**57 - 61 Archer Street & 34 Albert
Avenue, Chatswood**

BCA Assessment Report Report 2023/2107 R1.2

**Prepared for Chatswood Property Pty Ltd
October 2024**

BASEMENT 5

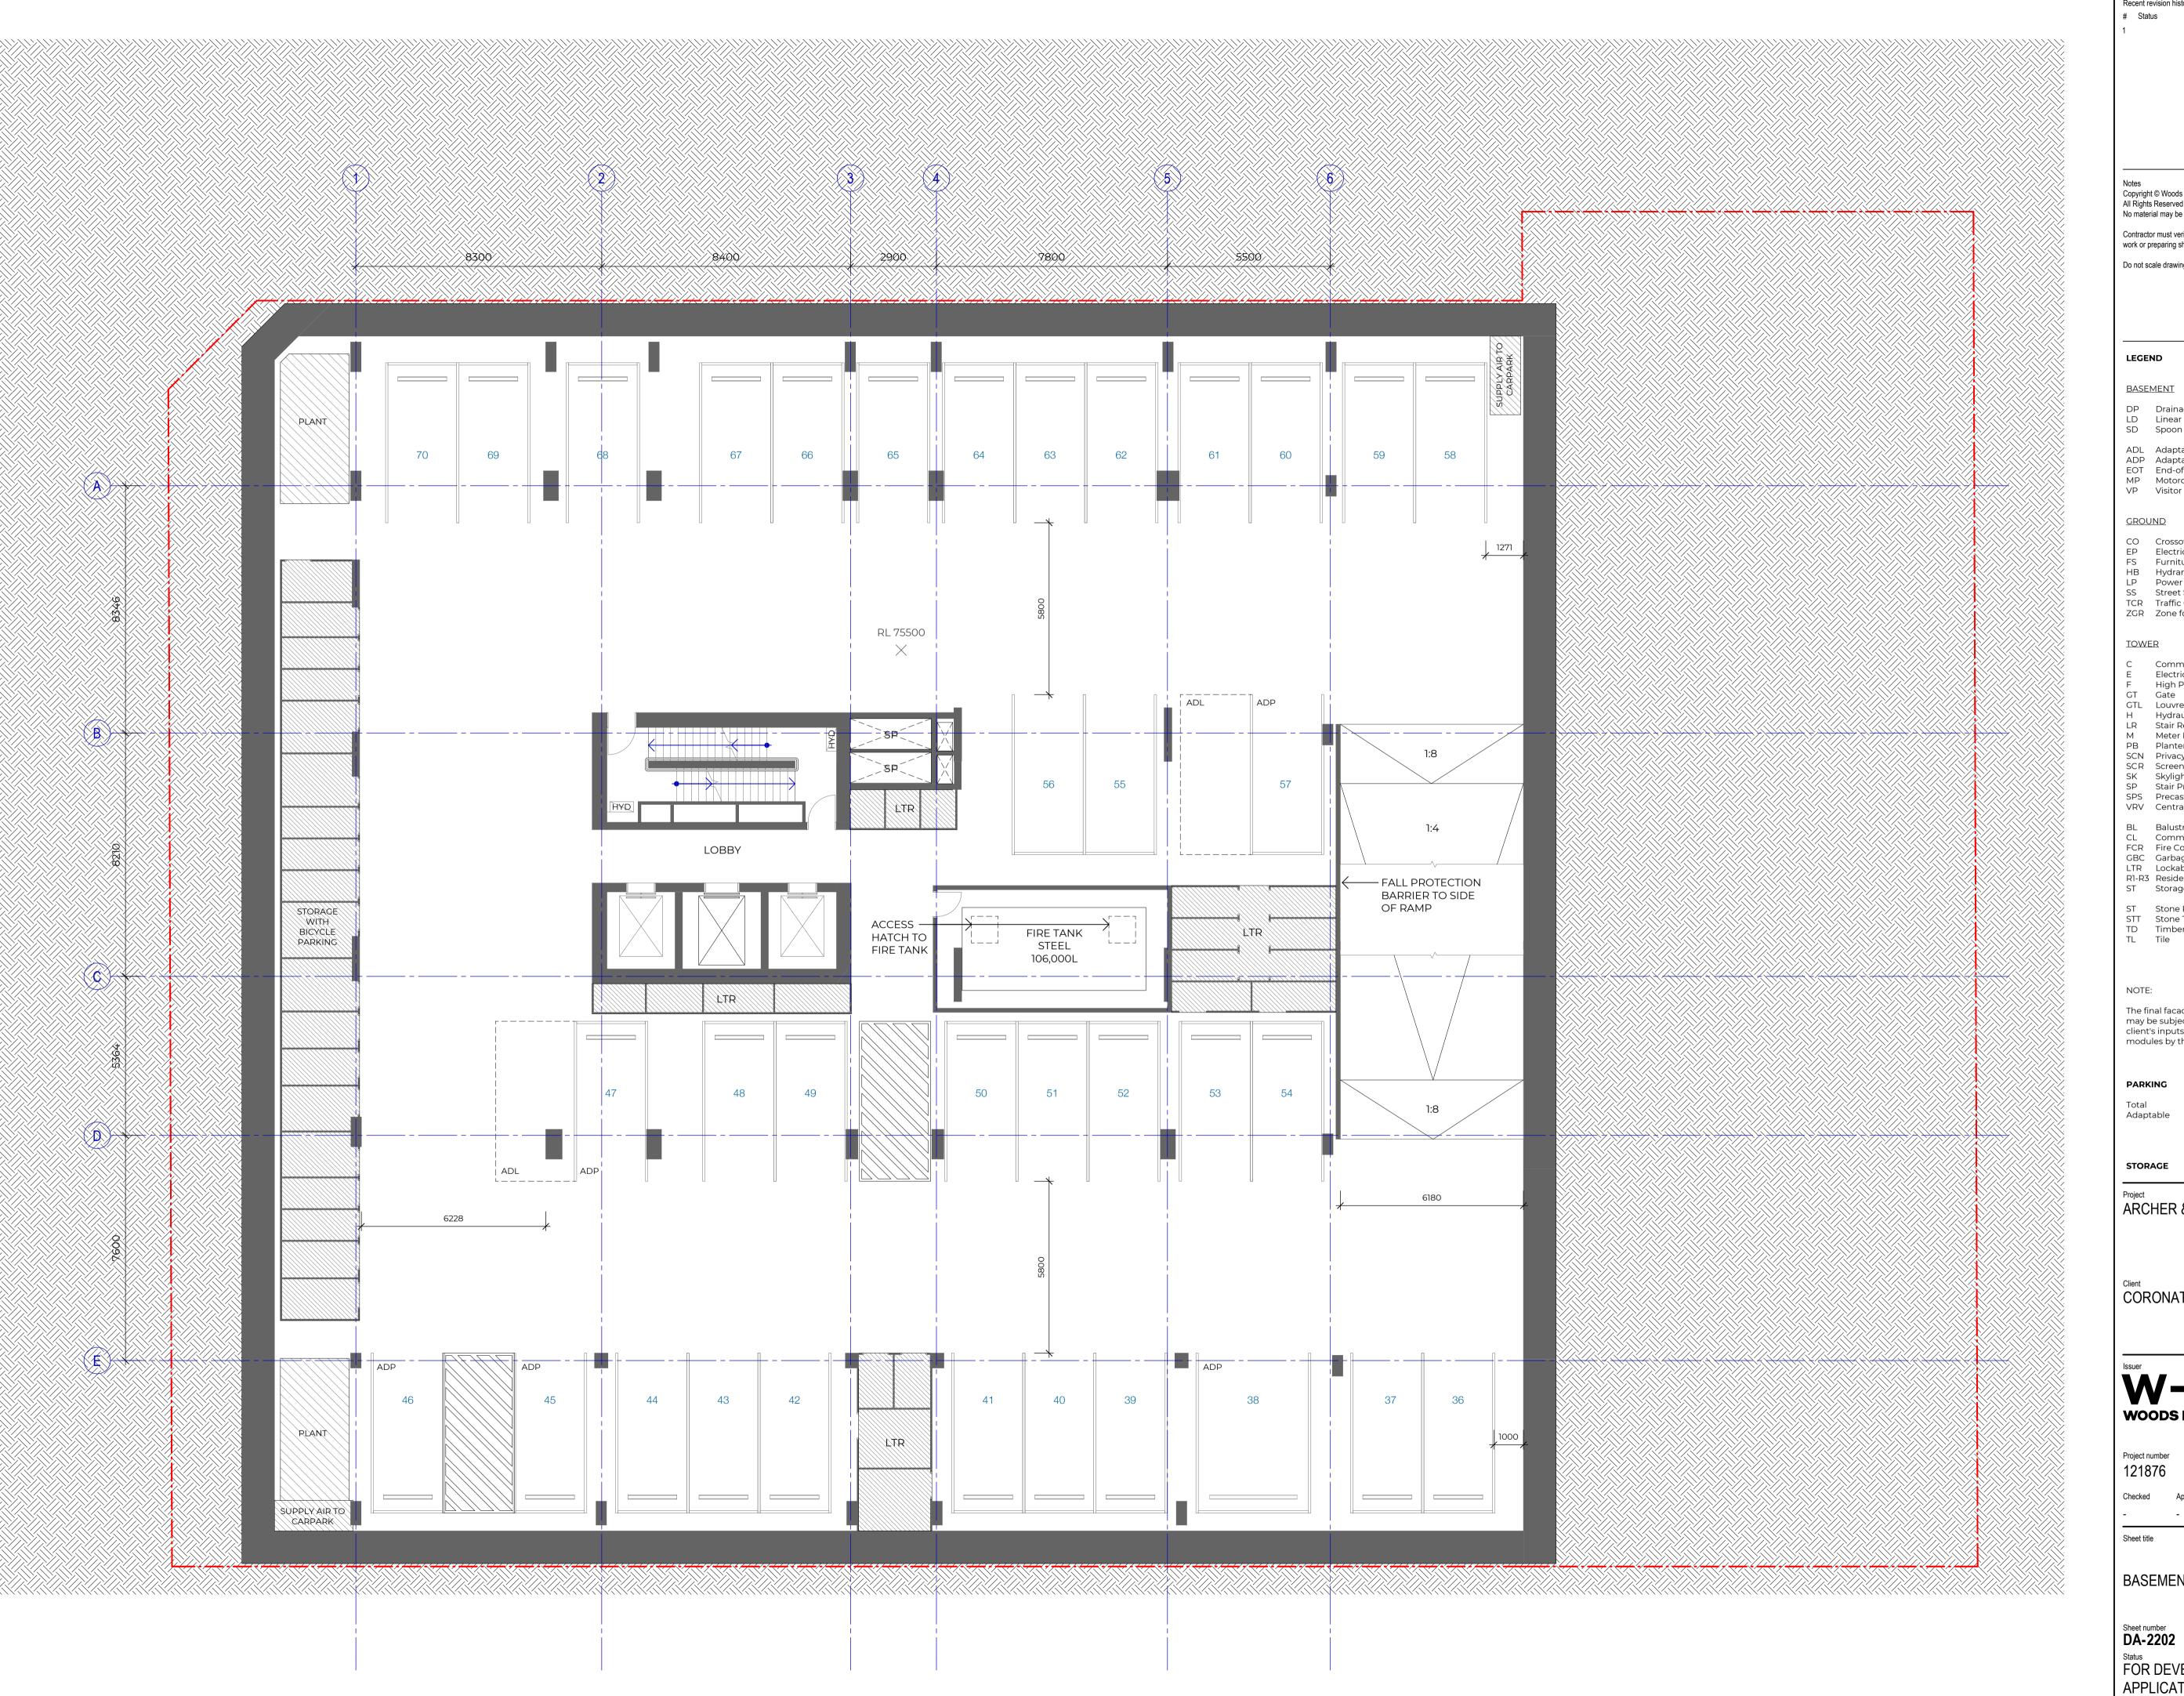
Item	Non-Compliance	DTS Clause	Description
1.	Fire resisting construction.	C3D8, C3D9 & Spec 5 -	The basement levels contain multiple classifications which are required to be fire separated. It is proposed to rationalise the FRL's to the following areas via Fire Engineering Performance Solution; Storage cages and basement carpark

4.	Exit travel distances	D2D5	The following areas have been identified with distances exceeding 20m to a point of choice: - B5-B3 25 metres to a point of choice. - B2 – 50m to a point of choice - B1 - 36m to a point of choice - GF – 22m to point of choice. - L1 – 29 m to point of choice. - L3-L8- 8m to point of choice. - Residential Levels 3-10- up to 9m to a single exit (point of choice) The following areas have been identified with distances exceeding 40m to an exit: - B2 – 53m to a point of choice

Item	Non-Compliance	DTS Clause	Description
1.	Height of rooms and other spaces	F5D2	It has been identified that within the basement level there will be reduced floor to ceiling height within the following areas; • Carpark exhaust plant room.

LEVEL 1

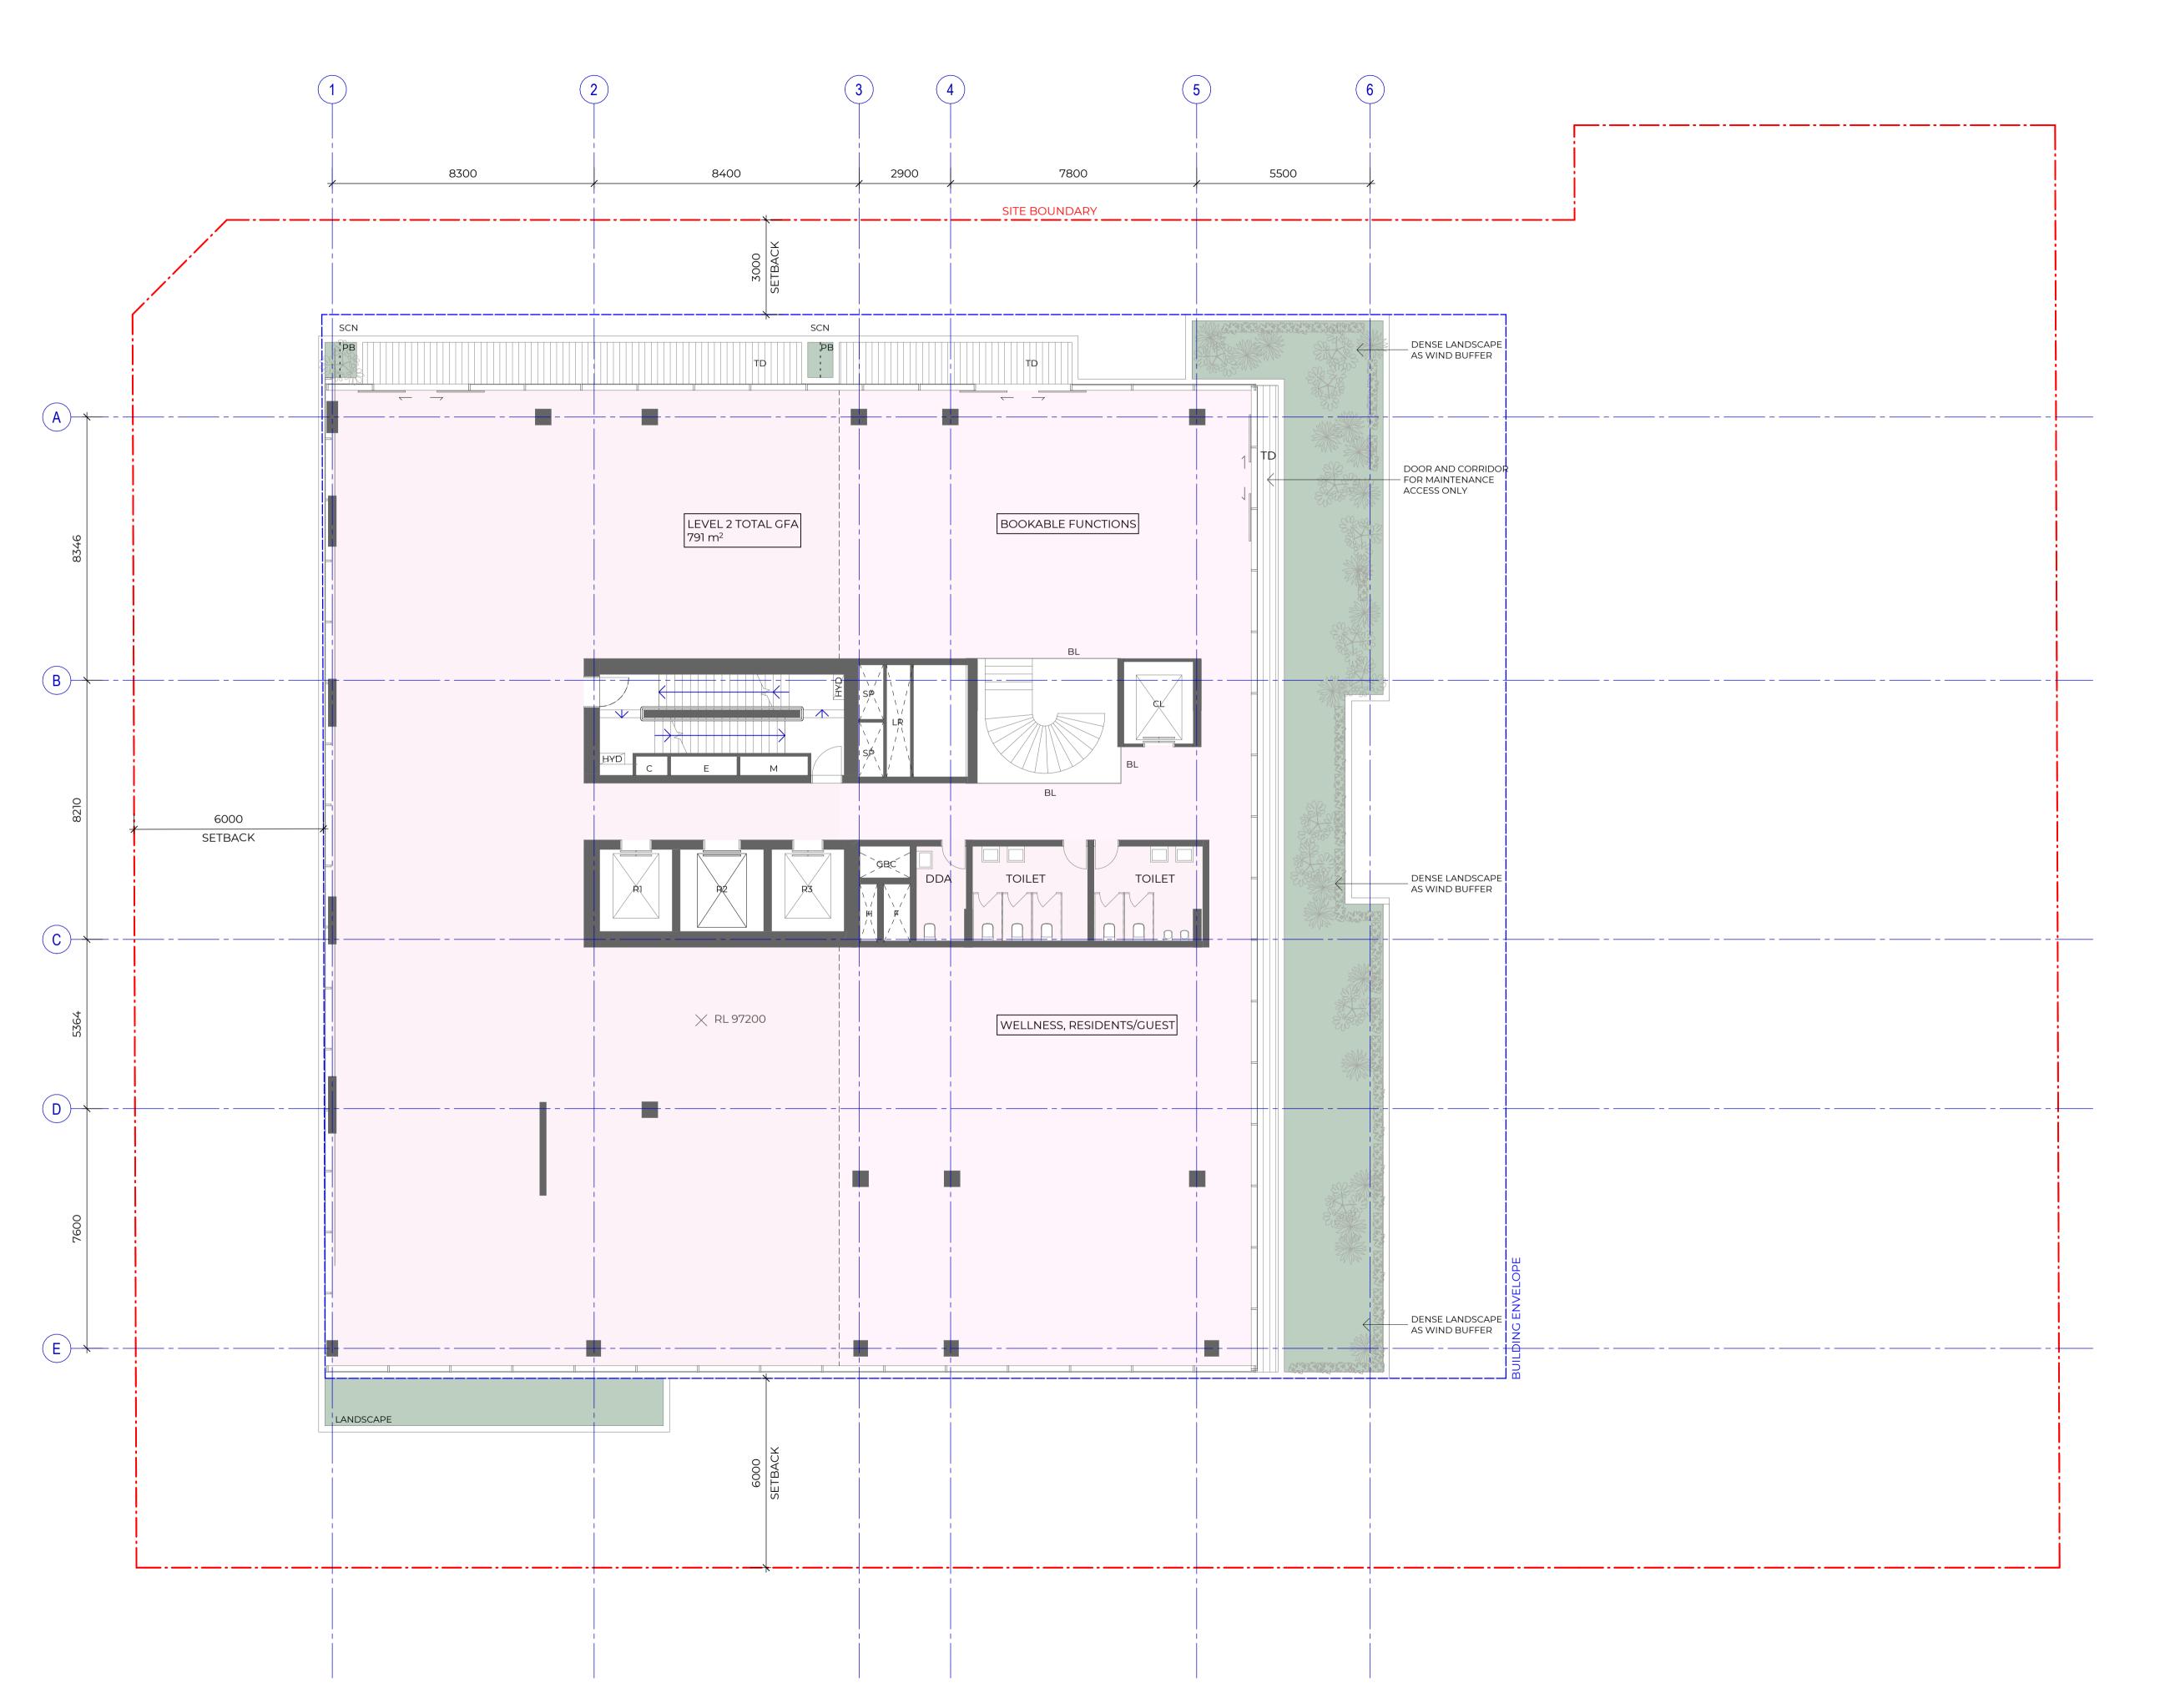
5.	Distance between alternative exits	D2D6	The distance between alternate exits serving the residential levels measures less than 9 metres. The distance between alternate exits in the following locations exceed 60m: - Level 1 – Measured up to 70m. - Level 2- Measured up to 75m
